Consultation Response from KC, Lead Local Flood Authority
2021/93270 Land at, Station Road, Skelmanthorpe, Huddersfield, HD8 9BA
Discharge of conditions 3 (construction management), 4 (temporary drainage), 5 (temporary waste arrangements), 7 (adoptable roads), 12 (waste storage and collection), 13 (tree protection), 14 (units 23 and 24 revisions), 16 (detailed drainage scheme), 17 (phase II report), 18 (remediation strategy), 23 (materials) and 31 (vegetation removal) of previous permission 2019/91657 for erection of 30 dwellings
Date Responded: 6th February 2023 Responding Officer: Paul Farndale Responding Ref:

Condition 16 – Drainage Design and Flood Routing

FLOW CONTROL MANHOLE - S6

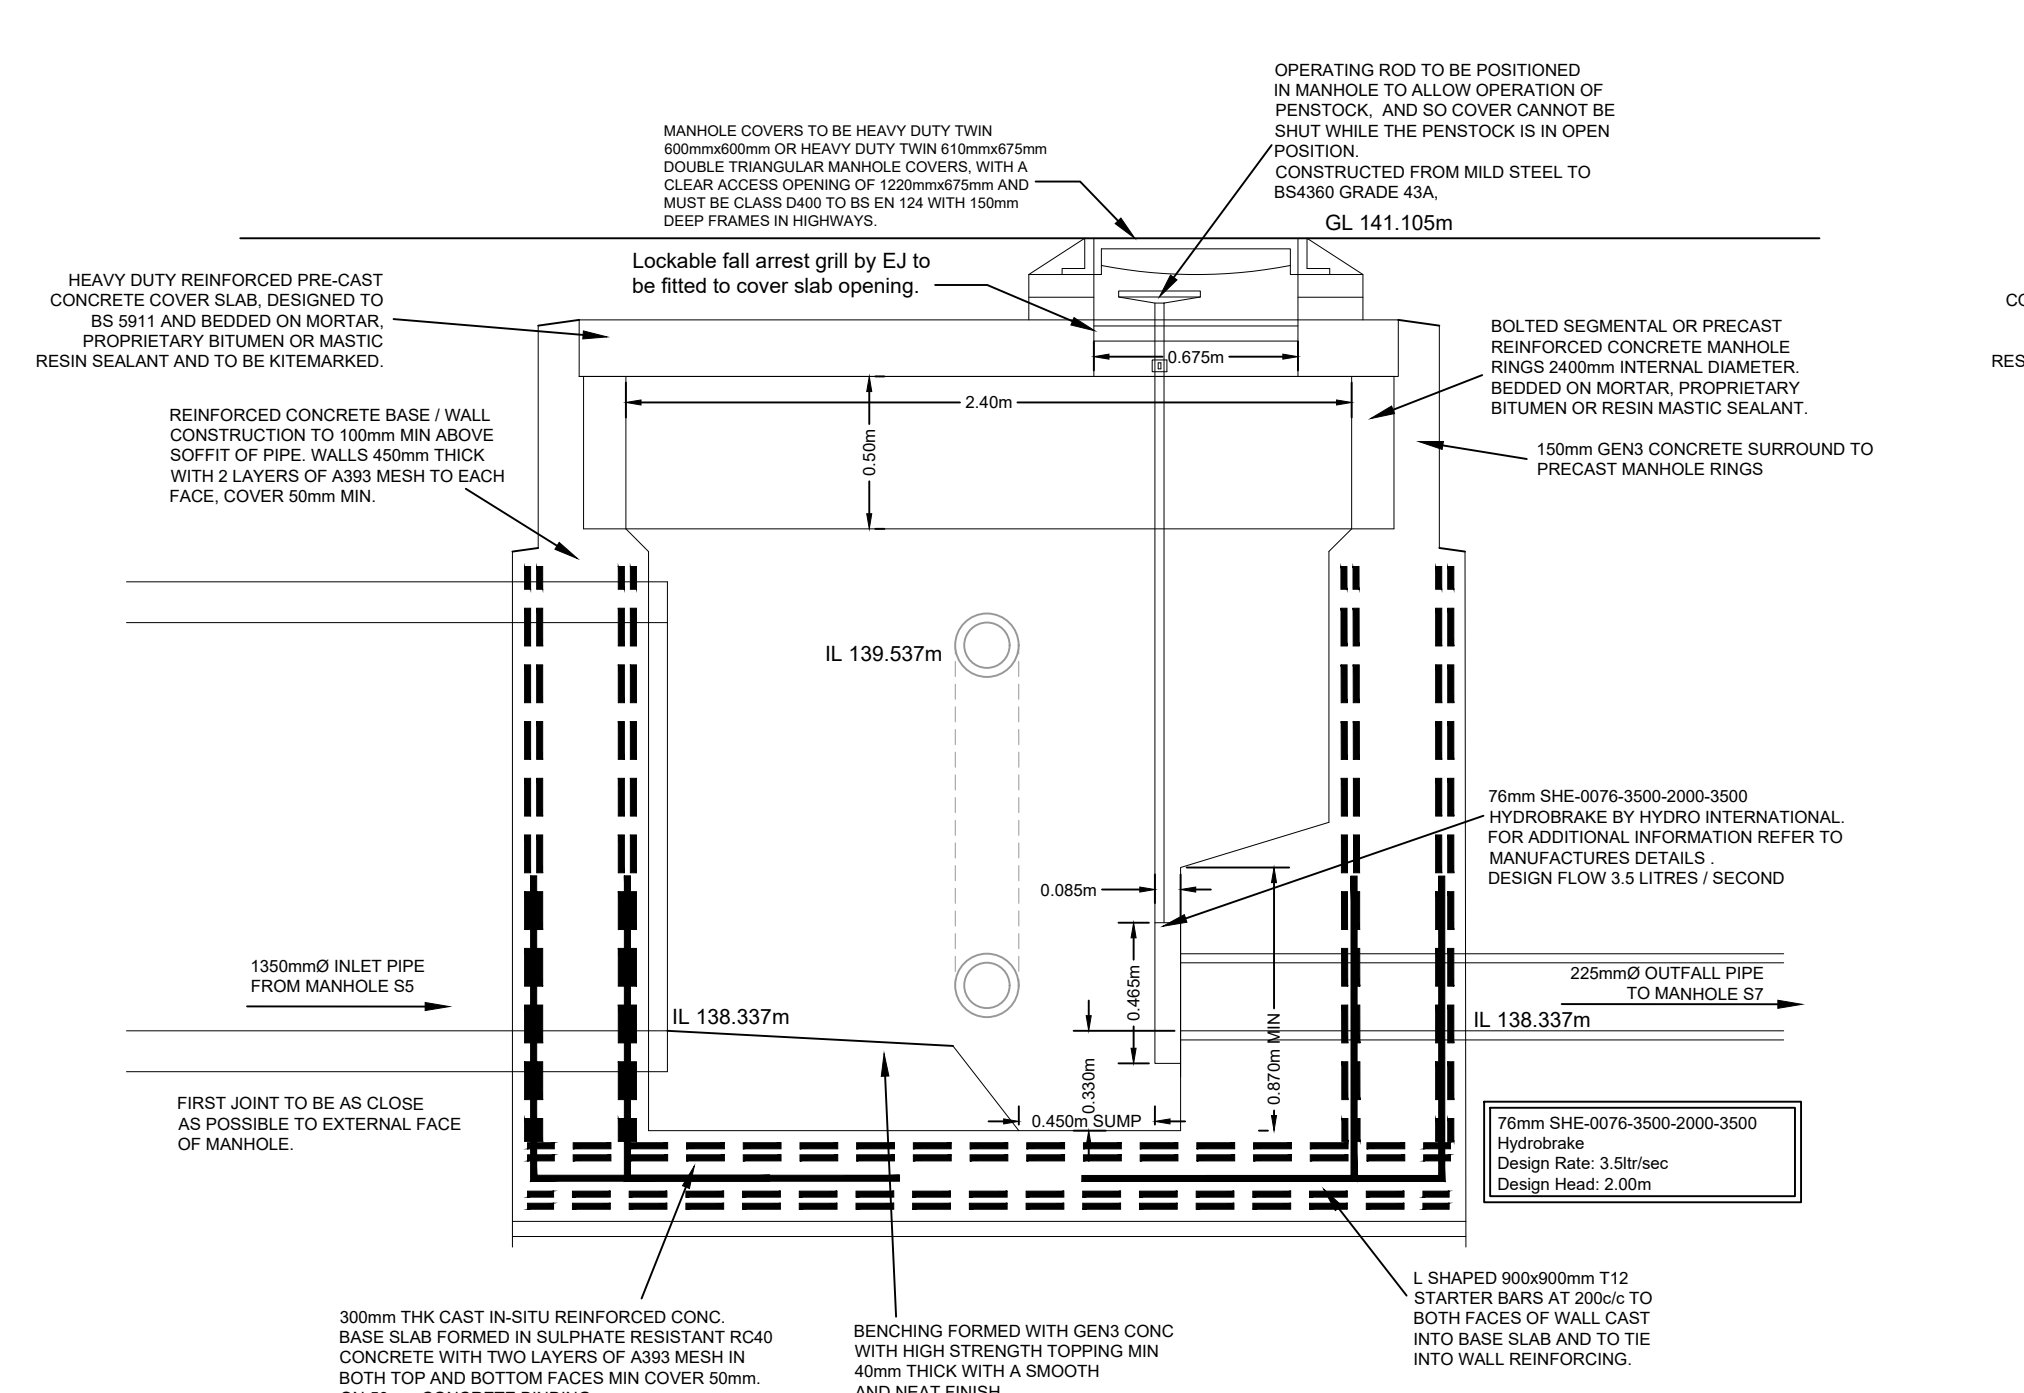
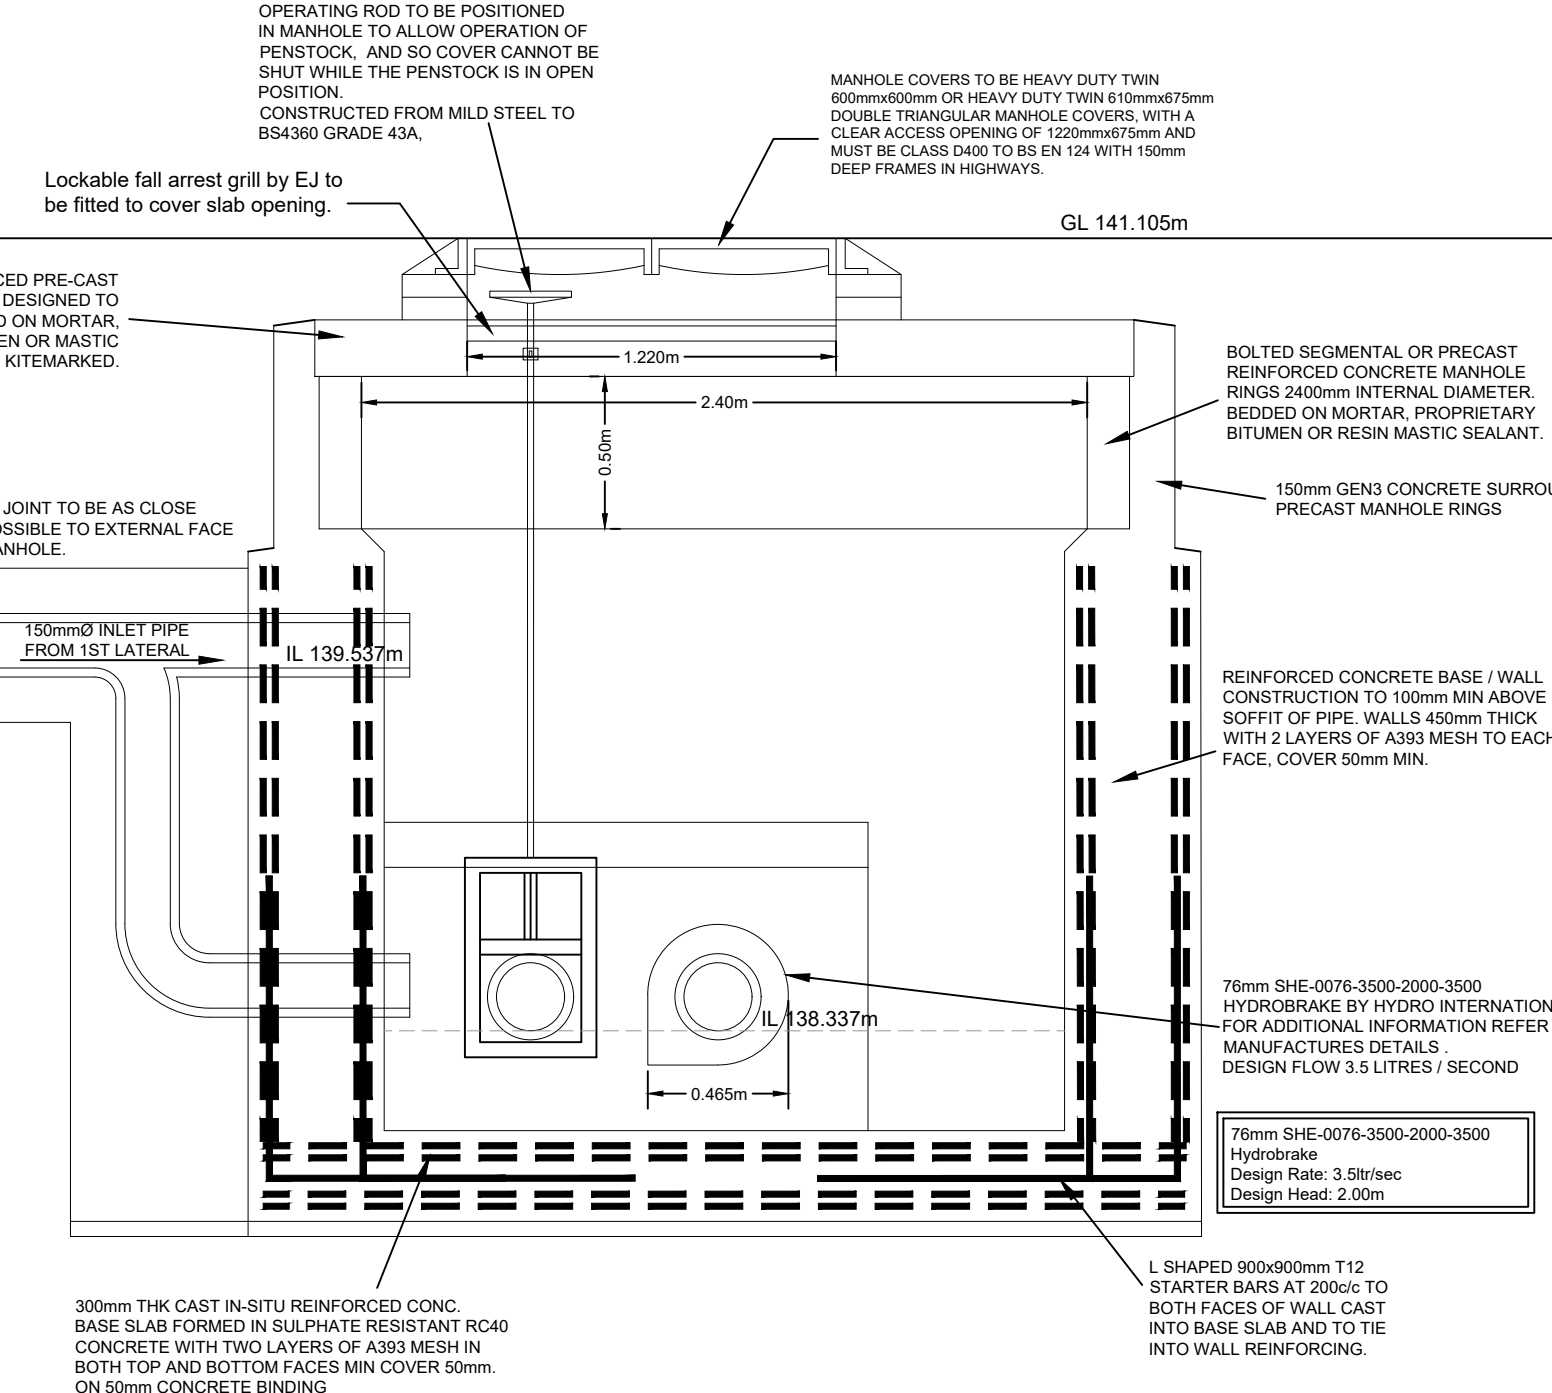
Regarding flood routing, detailed information has been submitted with Flood Routing Plan E18/7366/019E, alleviating previous concerns adjacent to plot 28 and around manhole S6.

We therefore recommend that this condition can be discharged.
